Application no: **3/2021/0335**

Address: **Ribble Valley View Old Langho Road Langho BB6 8AW**

Proposal: **Extension of existing holiday lodge park to provide for the siting of 16 additional holiday lodges. Resubmission of 3/2019/0851.**

The Local Highway Authority have viewed the plans and highway related documents and have the following comments to make:

dwg no. 901 job no. RS1108

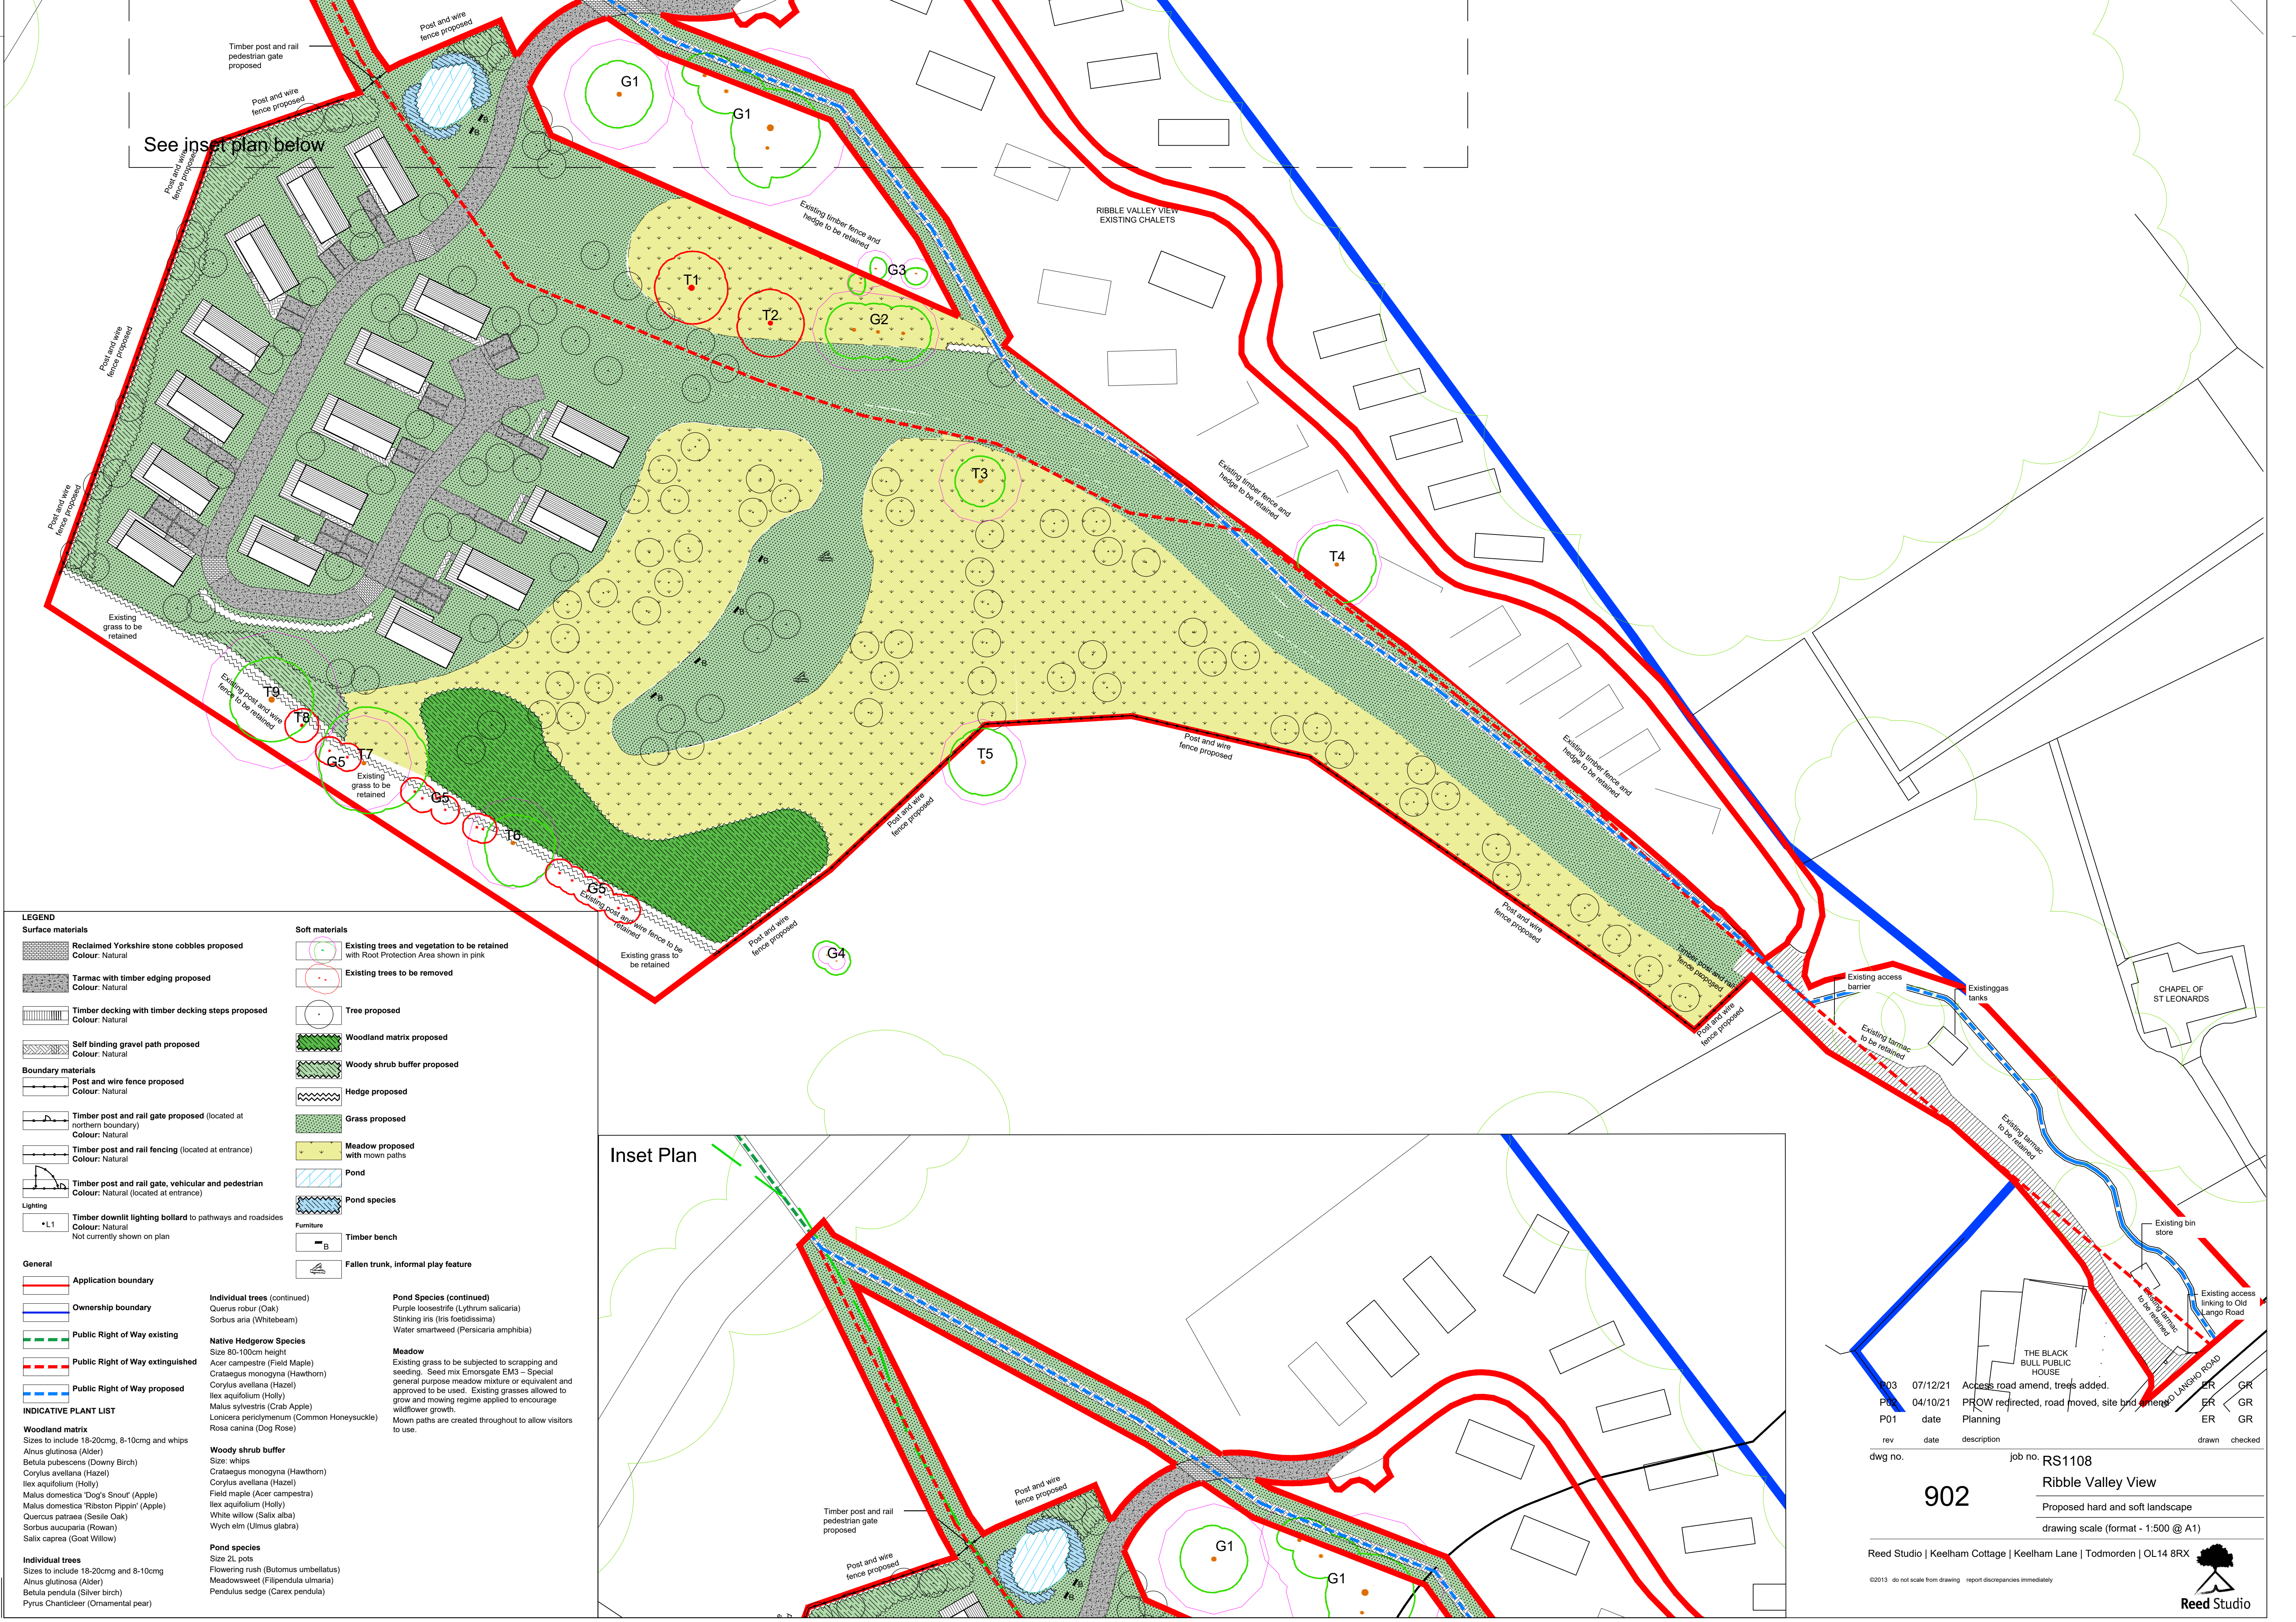
The LHA have reviewed Reed Studio drawing number 901 titled "Proposed Site Plan" and understands that a new internal road is proposed at the site which will be adjacent to Public Footpath 3-6-FP5. With the internal layout not being adopted due to the site being a private development and used for holiday lodges, the LHA have no comments to make regarding the internal road layout.

The drawing also shows that two car parking spaces for each 3-bed holiday lodge will be provided at the site. The LHA are satisfied that the proposed parking requirements meet the standards set in the Joint Lancashire Structure Plan and therefore have no further comments to make.

5. The development hereby permitted shall not be occupied until such time as the parking and turning facilities have been implemented in accordance with Reed Studio drawing number 901 titled "Proposed Site Plan". Thereafter the onsite parking provision shall be so maintained in perpetuity.

dwg no. 902

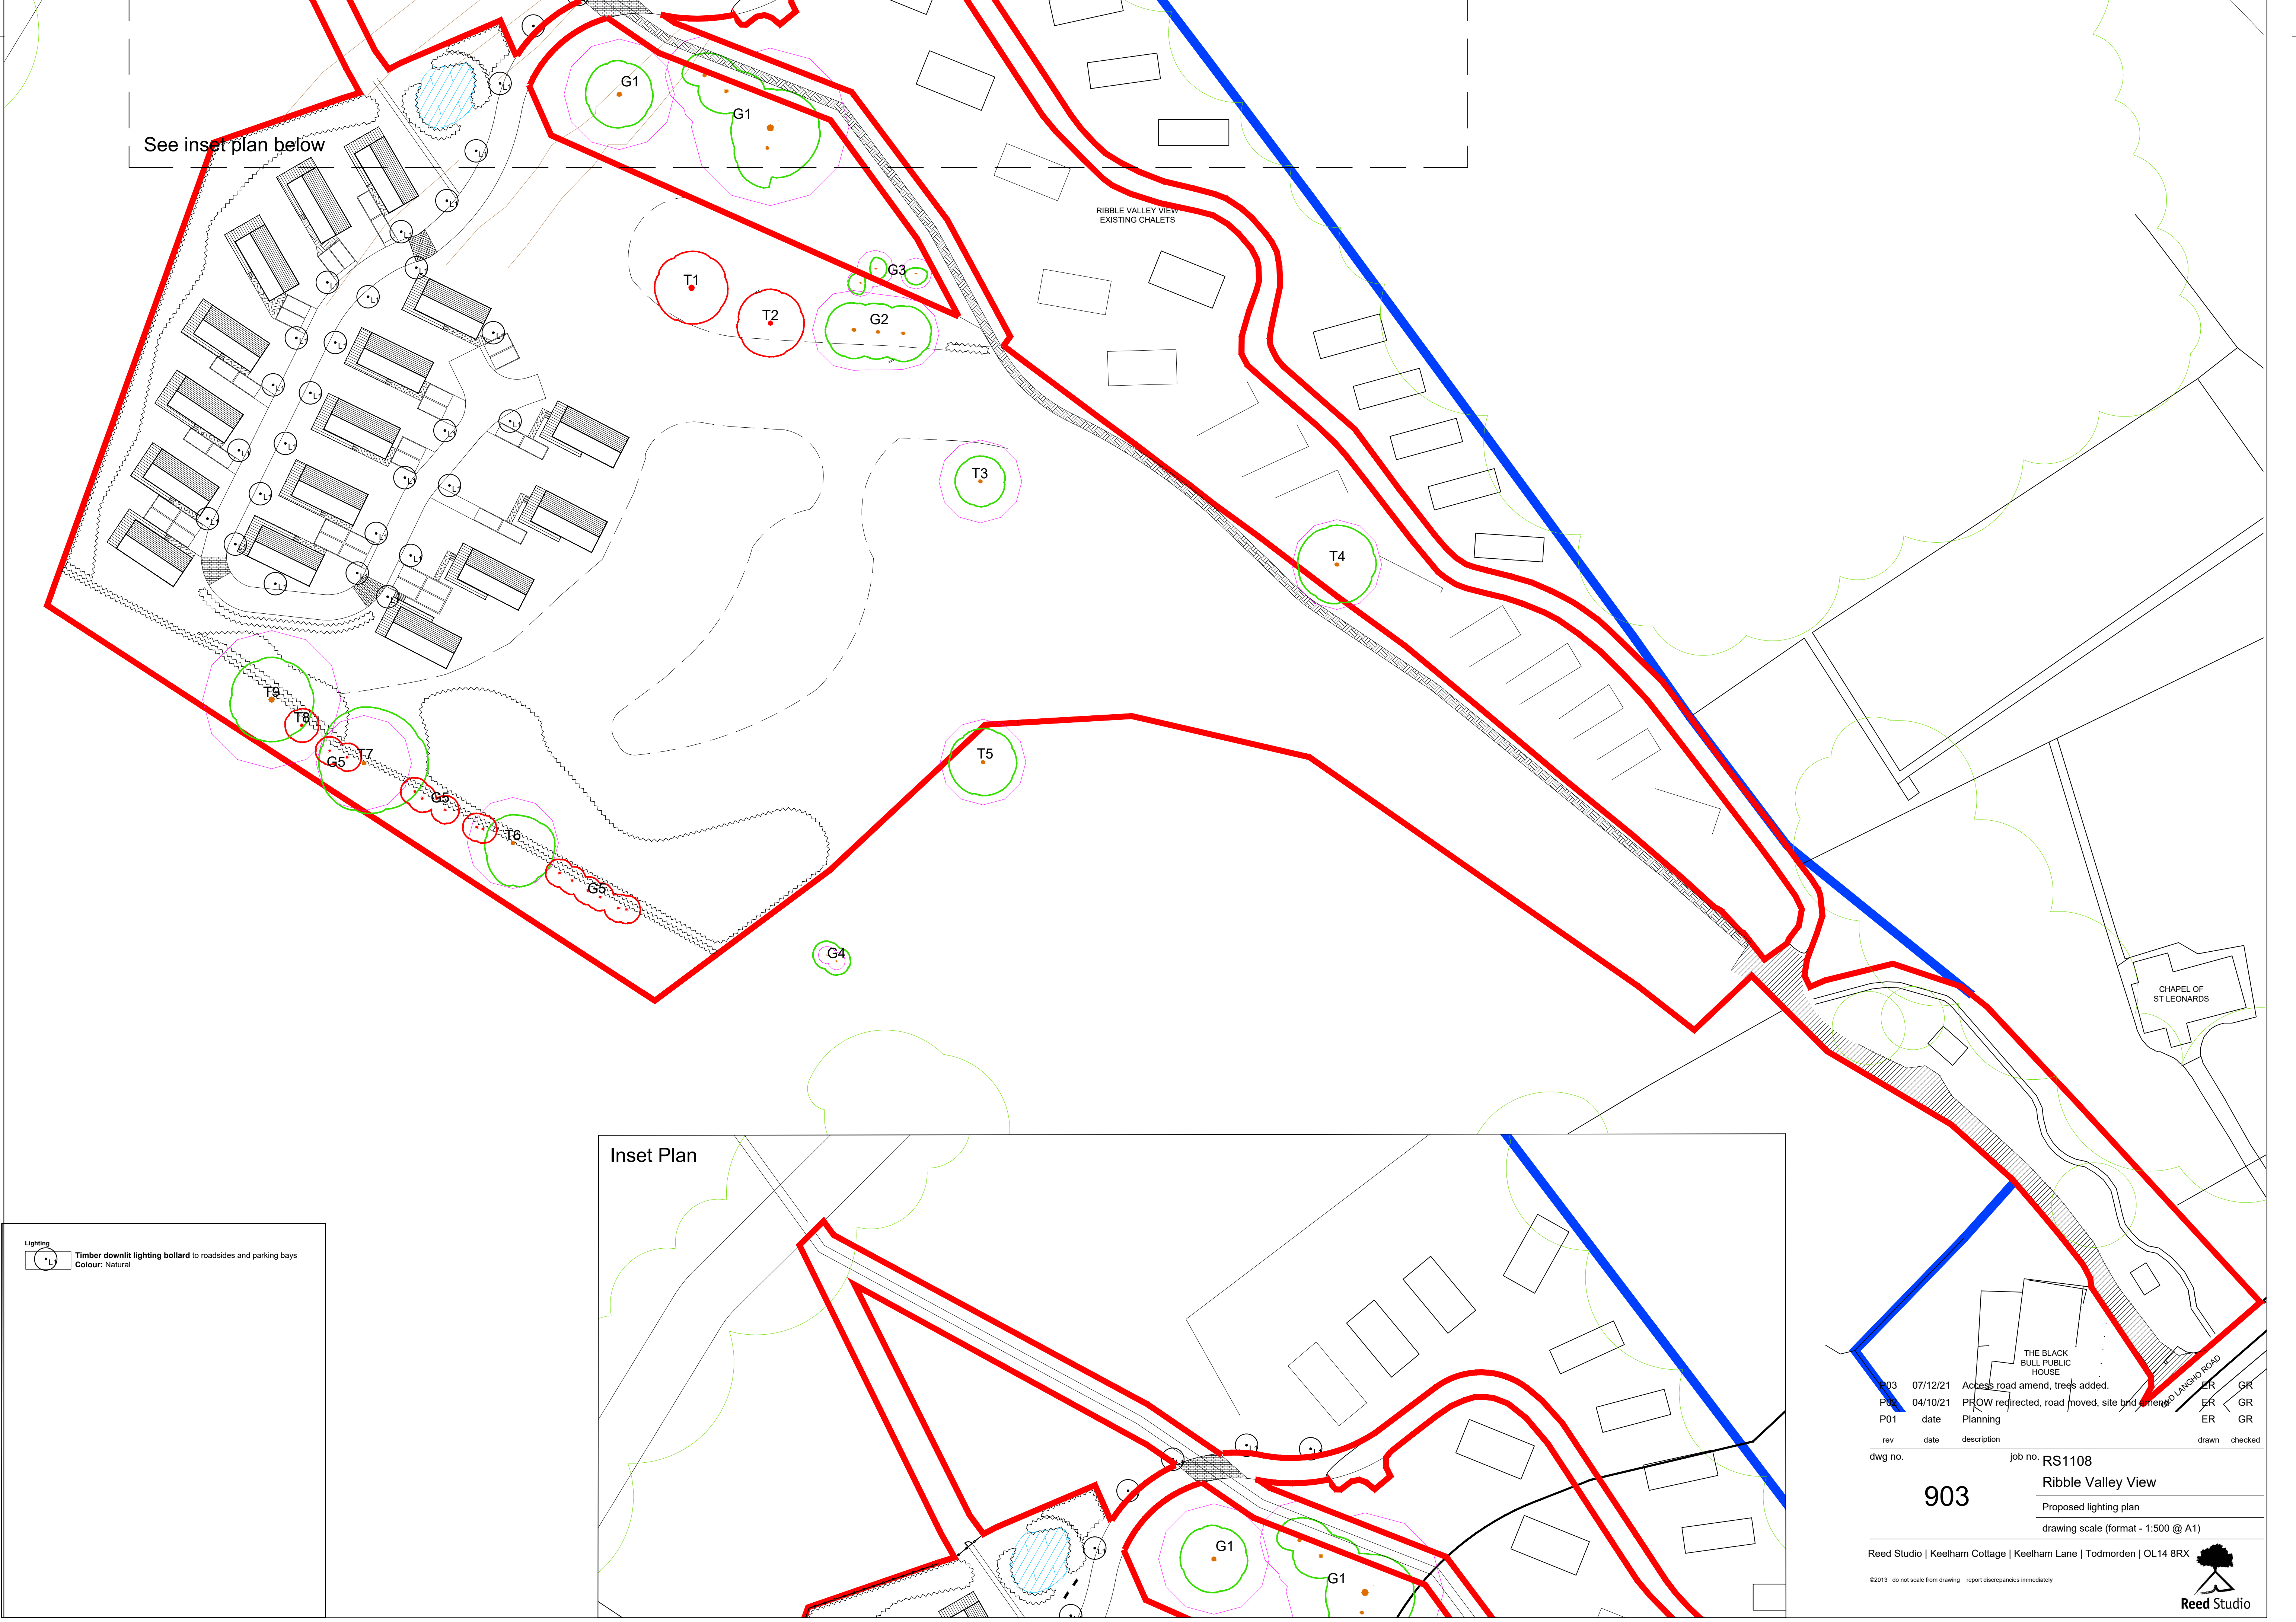
Public Footpath 3-6-FP5, as already mentioned, runs the full length of the proposed development and continues northward to a footbridge over Dinkley Brook. However, the Public Footpath, which is shown on Reed Studios drawing number 902 titled "Proposed hard and soft landscaping," does not have access to a segregated footpath along the side of the road which services the holiday lodges. Therefore, due to the existing business located at the site increasing in scale following the proposal, meaning that the use of the existing site access and internal road layout will intensify, the LHA will require the Applicant to provide a segregated footpath from the road. A segregated footpath will also be in the interest of pedestrian safety and should measure a minimum of 1.5 meters wide with a compacted bound surface.

The Applicant is also proposing to replace the existing agricultural gate and stile which is located at the entrance of the proposal. The gate is currently used to allow users to access the site as well as the Public Footpath. Therefore, the LHA advise the Applicant to consider the informative below which advises them to contact a member of the Public Right of Way (PROW) team to make sure the replacement gate and stile, meets the correct specification for a Public Footpath.

Furthermore, the Applicant is proposing to build a pond which is located at the northern boundary of the site, in close proximity to the Public Footpath. The LHA remind the Applicant that sufficient drainage is required to prevent surface water from running near or onto the PROW.

Not only this but the LHA have noted in the location near the proposed pond at the northern boundary of the site, the Public Footpath deviates from its definitive line. While the LHA acknowledge the deviation of the footpath in this location, could prevent drainage water from running down the gradient outside of the development towards Dinckley Brook, the Applicant will have to apply for a Diversion Order to make the diversion of the PROW a permanent feature at the site. The Diversion Order will have to be certified and in place before works can commence.

4. The development hereby permitted, shall not be occupied until the proposed segregated Public Footpath located adjacent to the existing internal road network, shall be constructed to a minimum width of 1.5 metres and be bound with a compacted bound surface. The Public Footpath shall be maintained for the duration of Public Footpath 3-6-FP5 which runs through the site.
